From: Amber Willard
Sent: 15 April 2019 10:48
To: Planning.Responses
Subject: FW: FP/46/19/PL
Attachments: APL 05.3 plans.pdf; APL 06.3 roof plan and sections.pdf

From: Amber Willard [REDACTED]
Sent: 12 April 2019 16:28
To: Ray Bell [REDACTED]
Subject: FP/46/19/PL

I am the case officer on your application FP/46/19/PL at 28 Sea Drive.

Dwg Reference:
Roof plan as proposed

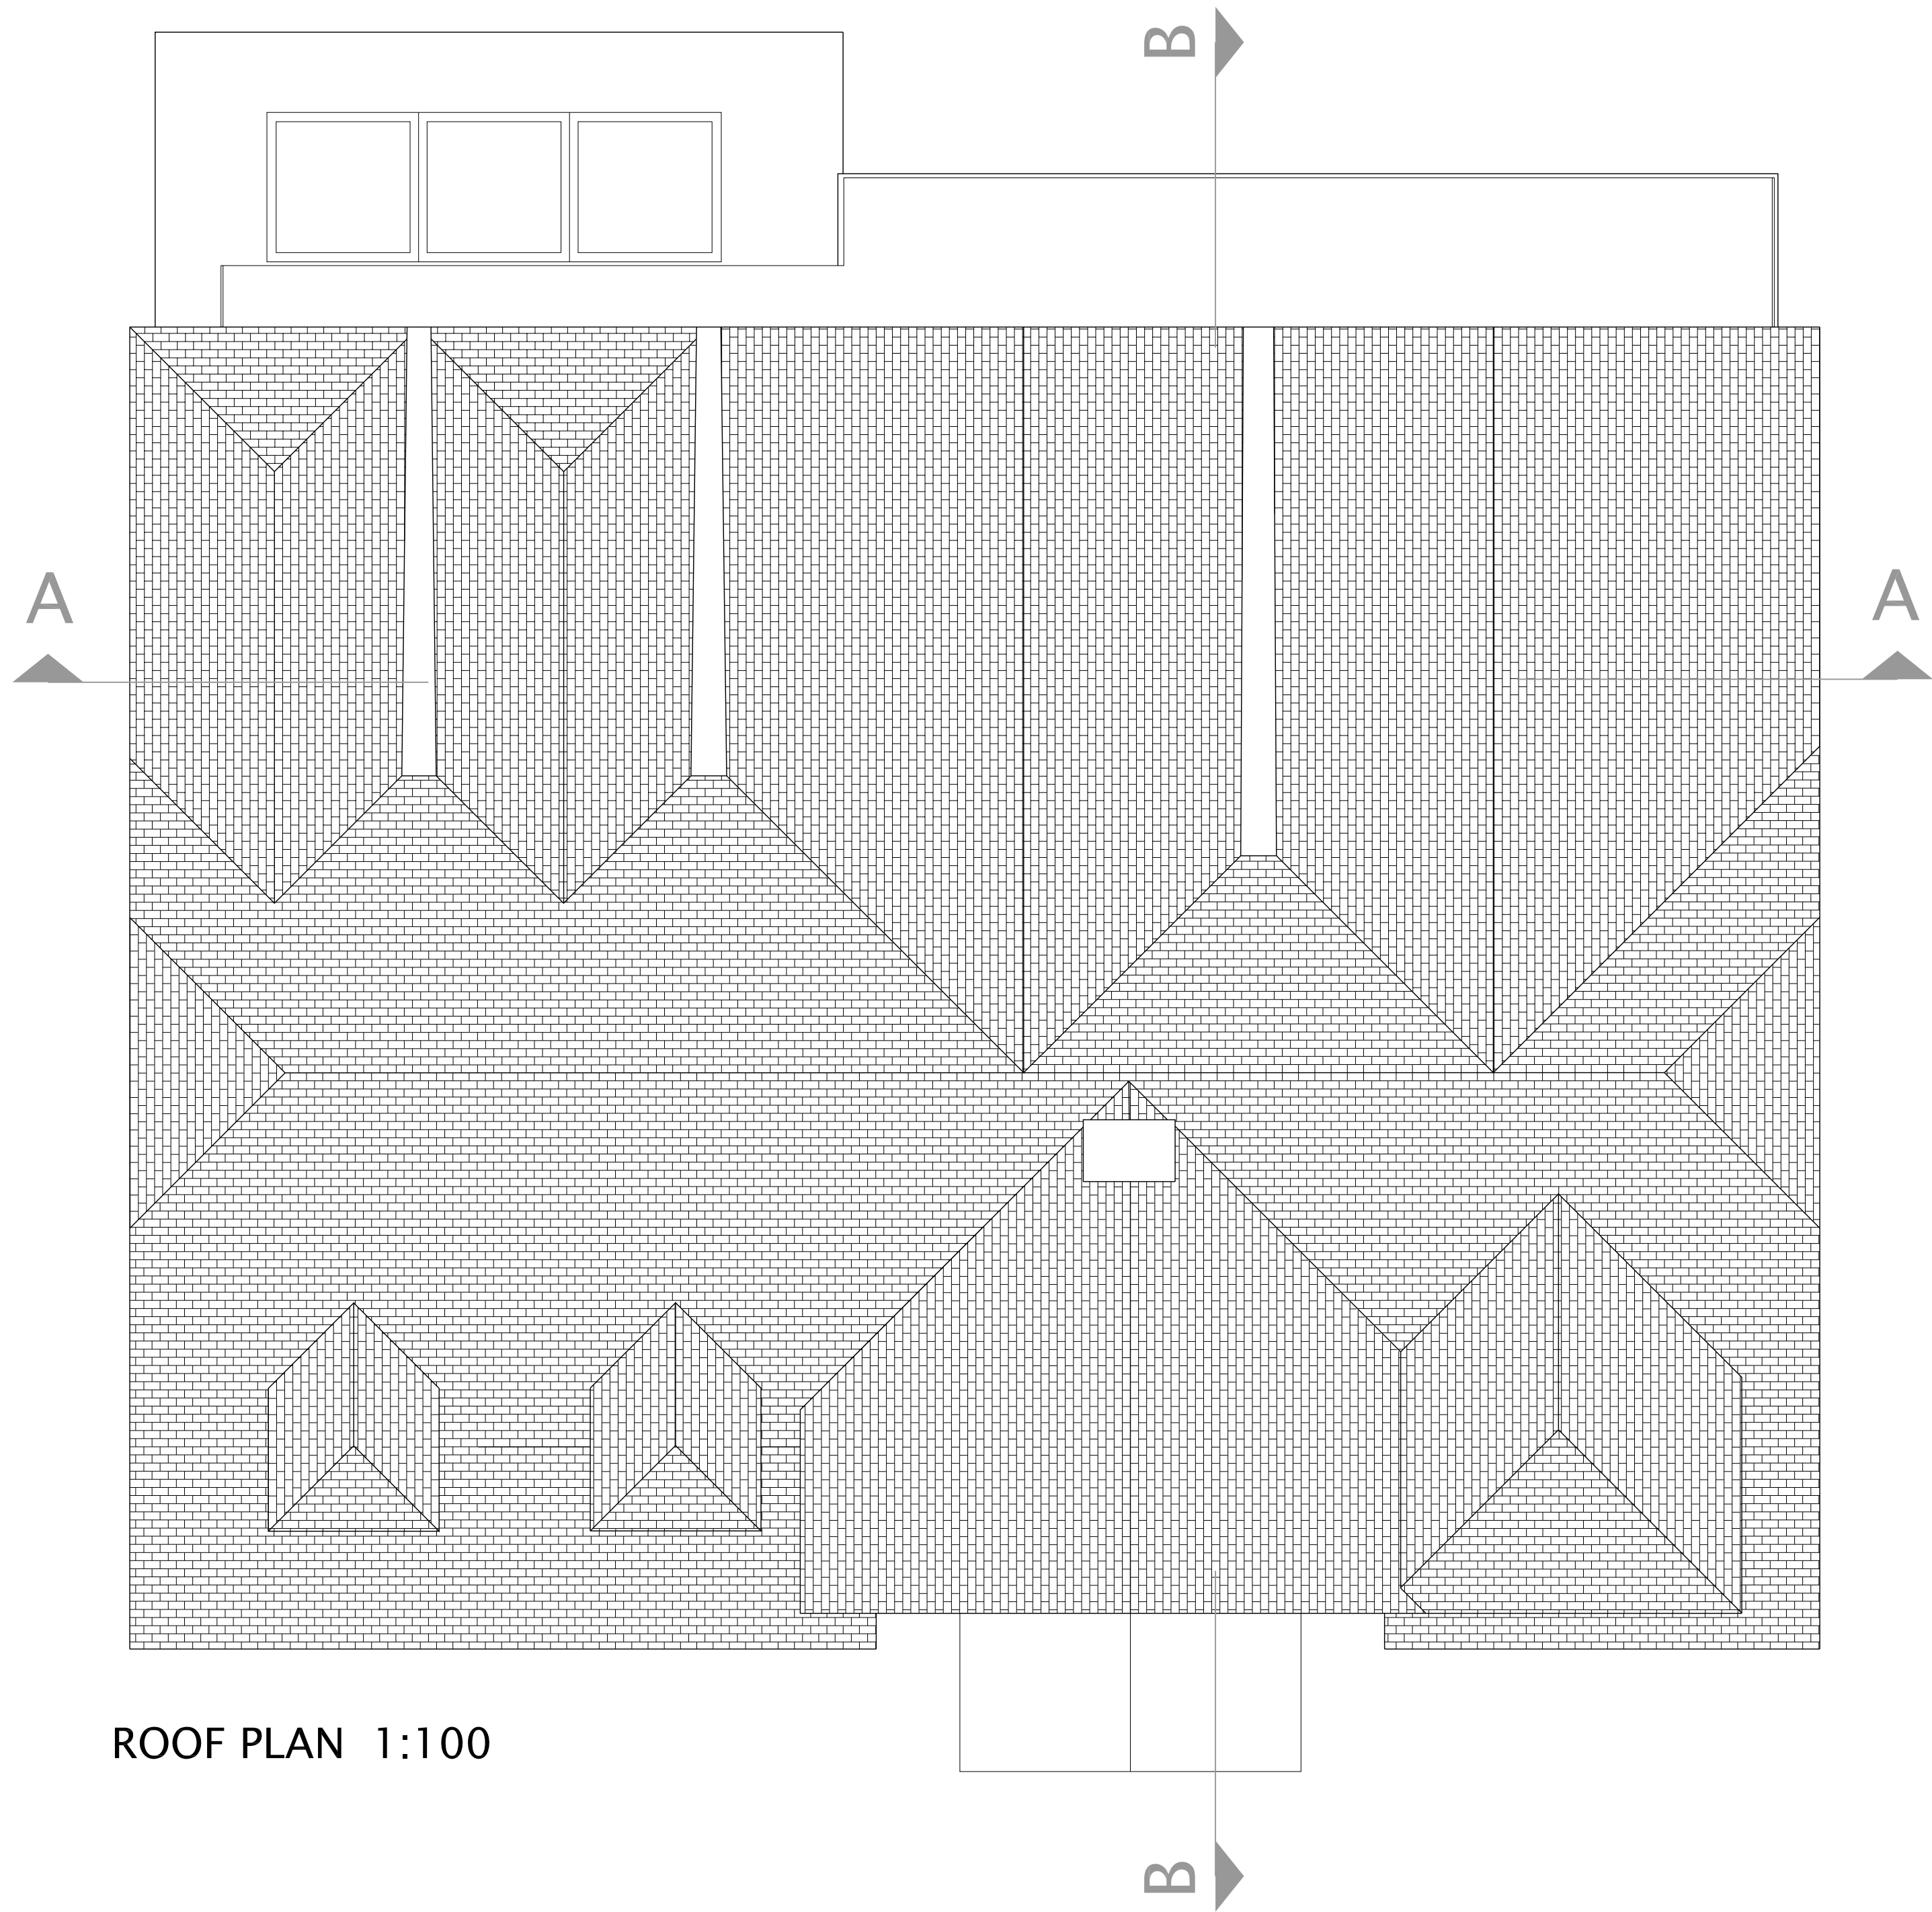
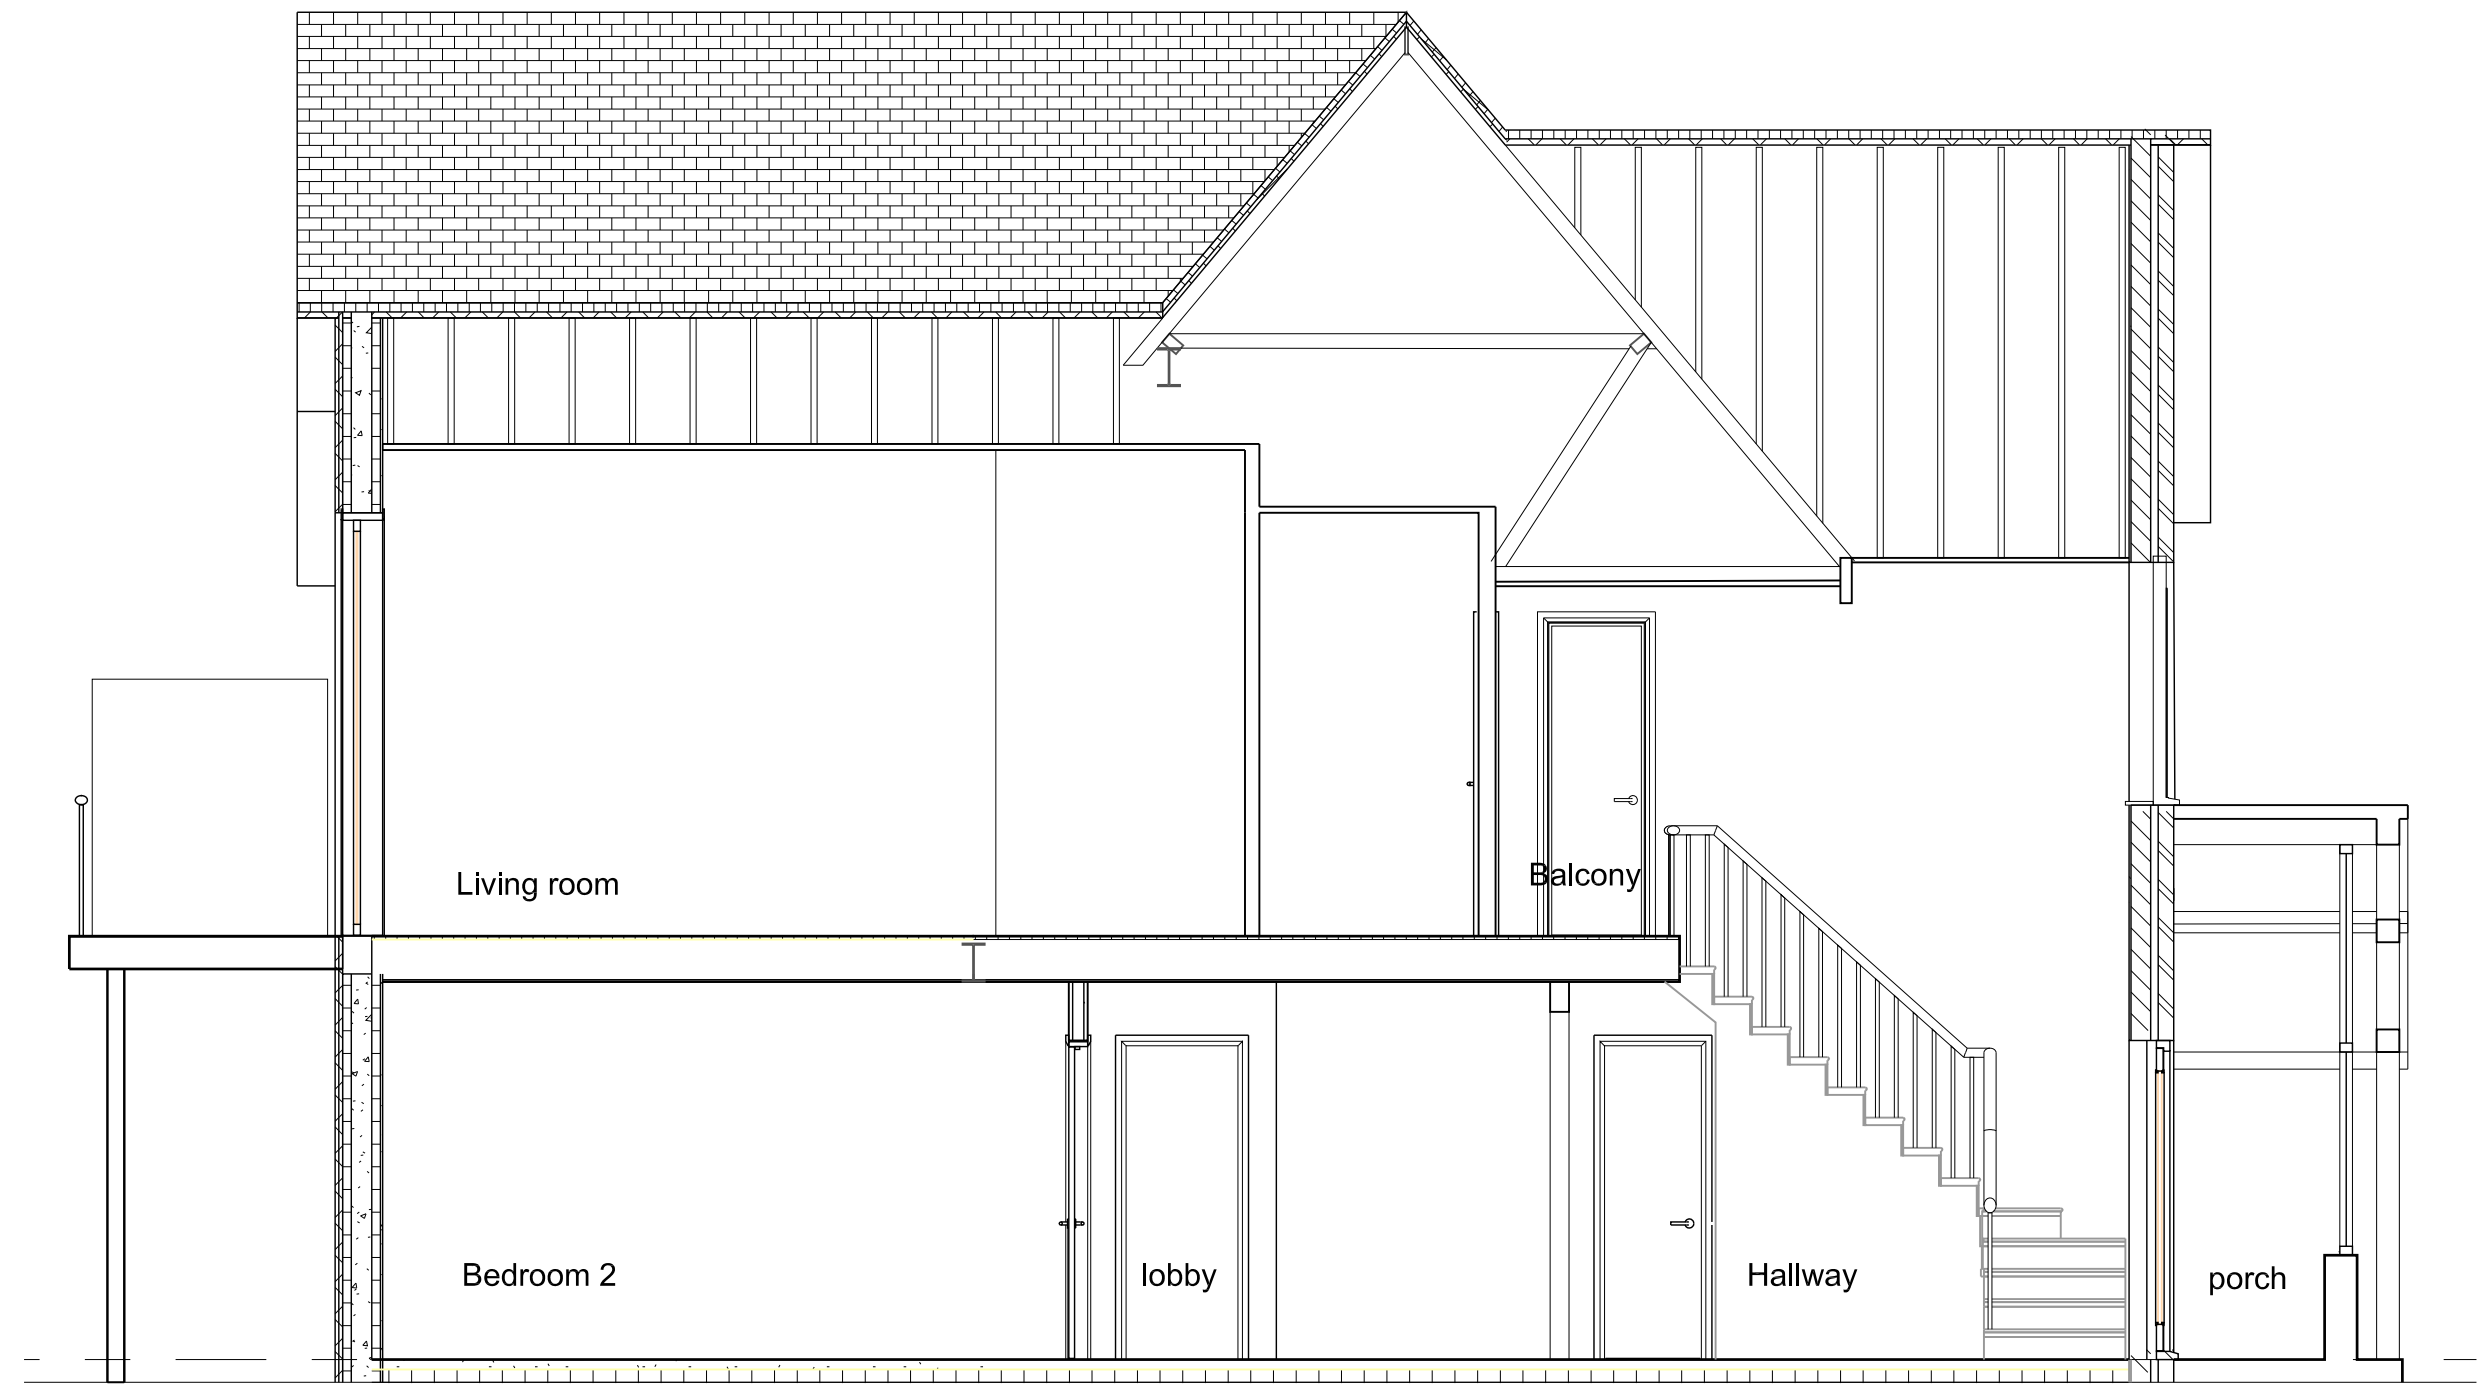
However on the proposed elevations ,roof and floor plan the balcony appears to have been extended towards the east and only retains around 1.3m

Please can you confirm which is correct and amend as necessary.

My apologies, I inadvertently sent out-of-date plans. The attached drawings APL 05.3 and APL 06.3 show the correct layout.
